Objection to The Amended SSD 7056, November 2016

I welcome aspects of the amended proposal as detailed in Response to Submissions Report October 2016 Amended Proposal and Revision C of Plans EA-A and I congratulate The Department and Applicant on the removal of the previously proposed 4 storey glass box structure which was to be constructed between Campbell's Stores and the Park Hyatt Hotel.

02 EAST ELEVATION
SCALE: 1:200

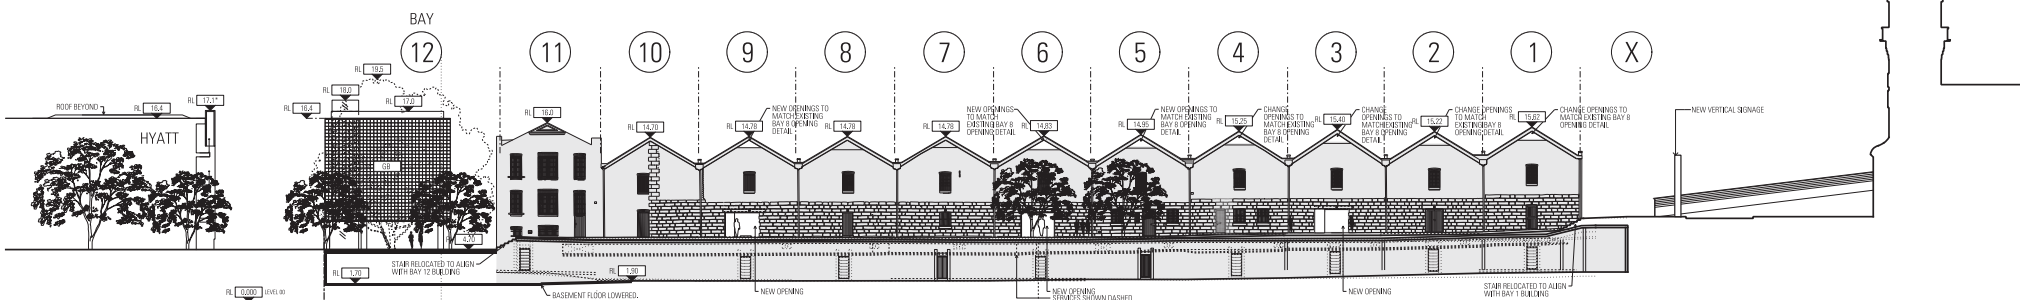
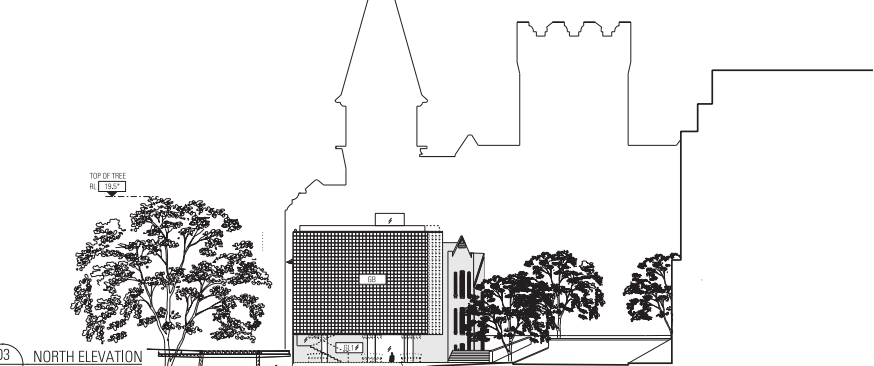
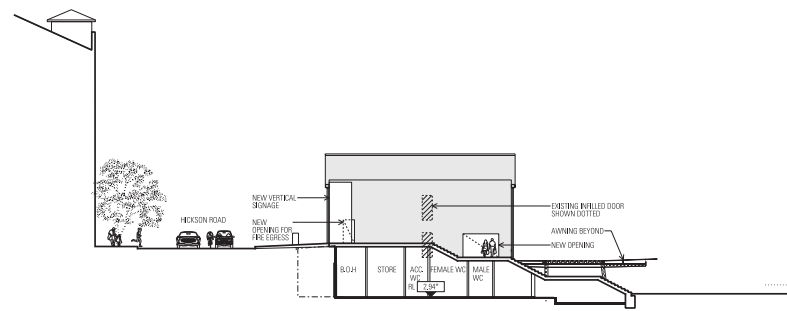
The proposed passive ventilation design will require Campbell's Stores' windows and doors opening onto Hickson Road to be open for much of the year. The 'open window' ventilation design will fail to contain noise within the premises and will result in significant noise impact on the residents of 8 Hickson Road and the guests of the Park Hyatt.

3. That no amplified music, live or recorded, and no amplified noise including speeches occur in outdoor areas at any time.
4. That windows or doors opening onto Hickson Road be kept closed at all times and windows be fixed in a closed position. In respect to openings required for access to Hickson Road, air lock style automatic opening and closing doors need to be fitted and designed, installed and operated so that one of each pair of doors will always be in the closed position at any given time.

**Figure 5** | The approved (left) and proposed (right) Bay 11 roof layout (Source: JPW Architects).

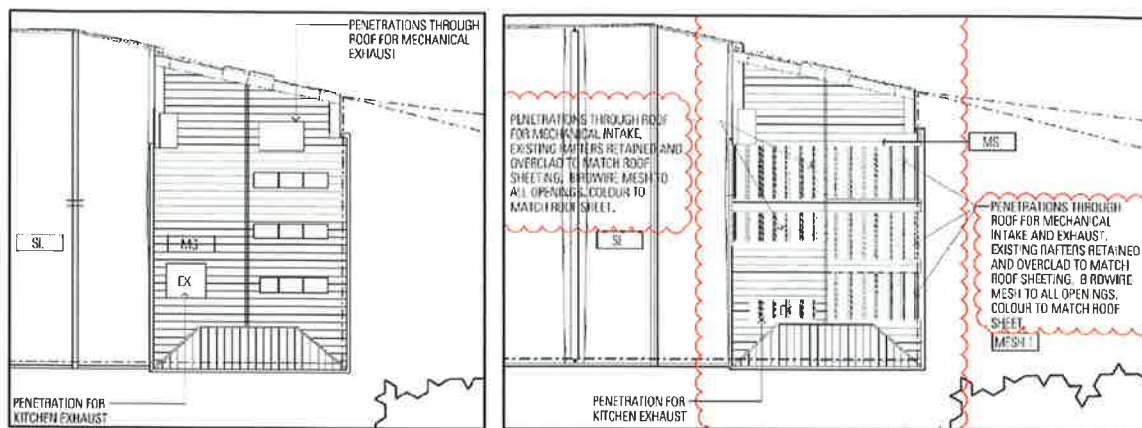
The proposal to relocate all the mechanical exhaust system for kitchens and other areas from the southern end of the building to the roof of Bay 11 will result in substantial impact on our amenity due to noise, vibration, smell and fumes emitted from the exhaust system and its close proximity to the windows of our apartment. It will also have a significant impact on other residents at 8 Hickson Road and the guests of the Park Hyatt.

While a detailed design has not been submitted the Roof Plan, EA-A-1005 Revision C and Level 04 Plan, EA-A-1005 Revision C, indicate 18-20 kitchen exhaust fans discharging through the roof of Bay 11. The proposal envisages converting the entire roof space of Bay 11 into a huge exhaust system, all located within approximately 25 metres of 8 Hickson Road and the Park Hyatt.

Even though the applicant has not submitted a detailed design for the mechanical exhaust system both the mechanical ventilation report and noise impact report state that in order to reduce smoke, smell and noise impacts of the system a riser of unspecified height and noise baffles, of unspecified design, will be required on the roof of Bay 11 in an attempt to mitigate the amenity impacts of the exhaust system.

The proposed risers and noise baffles for the mechanical exhaust system on the roof of Bay 11 will substantially and negatively impact on our views of the Sydney Opera House and Sydney Harbour from the living room and bedroom of our apartment on level 3, 8 Hickson Rd.

6. That all of the mechanical exhaust system including machinery, flues, vents and baffles be located at the southern end of Campbell's Stores so as to minimise noise, fumes, vibration and smell impacts on the residents of 8 Hickson Road and guests at the Park Hyatt Hotel.

7. That there be no penetrations, structure or any plant, including flues, vents, plant or equipment located through or on the roof of Bays 9,10 and 11
